# CITY OF PORTLAND BUILDING PERMIT

Job ID: 2012-01-3060-CH OF USE

has permission to Establish the use of Bldg #3, Unit #4 & 5 as warehouse/office with alterations to the mezzanine provided that the person or persons, firm or corporation accepting this permit shall comply with all of the provisions of the Statues of Maine and of the Ordinances of the City of Portland regulating the construction, maintenance and use of the buildings and structures, and of the application on file in the department.

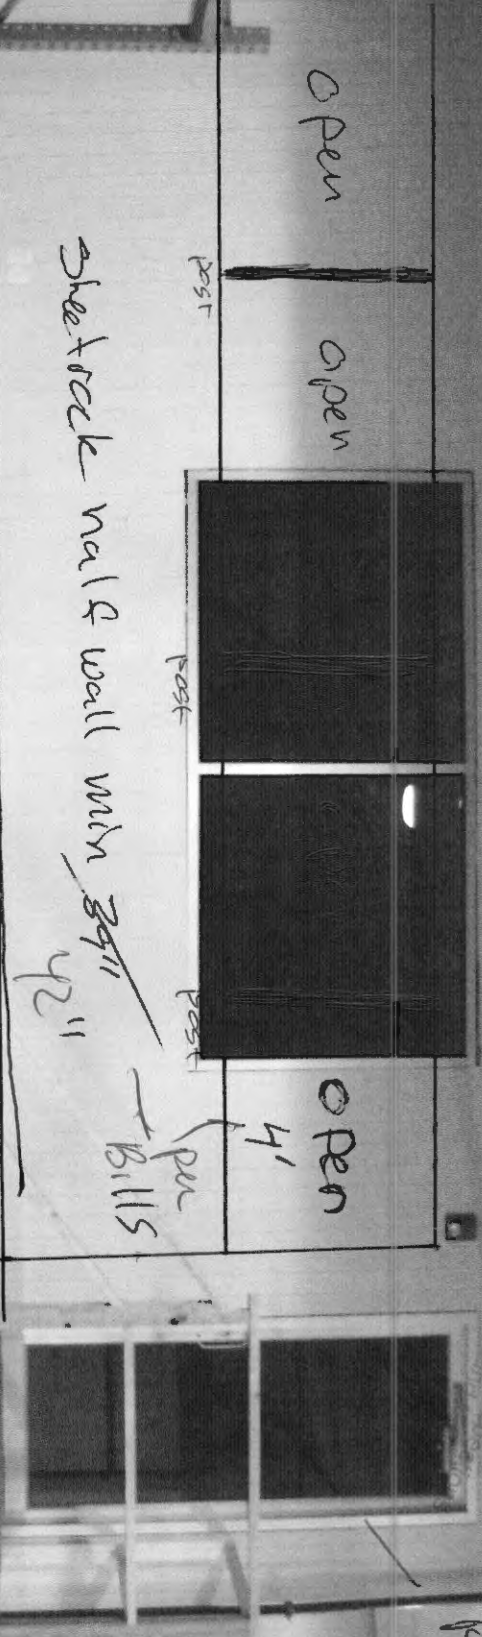
4/27/12 spoke w/ James (contractor) about the existing  
Guard - It is 36" at nosing - he is just adding balusters  
to L 4" and a cap ~~top~~ rail w/ mounted 36" graspable  
(returns) handrail. Guard is 42" at landing. Since this was  
existing at 36" it is allowed to remain. JMB

2. Permit approved based on the plans submitted and reviewed w/owner/ contractor, with additional information as agreed on and as noted on plans, including the stair guard and handrail heights & opening limitations.

- 1.) Remove existing sheetrock walls above 42" for entire interior perimeter
- 2.) Remove existing door
- 3.) Remove existing window 34"-38" returned both sides
- 4.) Install round hand rail at 42" from nose of stair tread to the base of the stairs
- 5.) Install spindles or plastic lattice below stairway railing to less than 4" openings for entire length
- 6.) Install spindles or plastic lattice below landing at the top of the stairway to less than 4" openings for entire area at 42" high
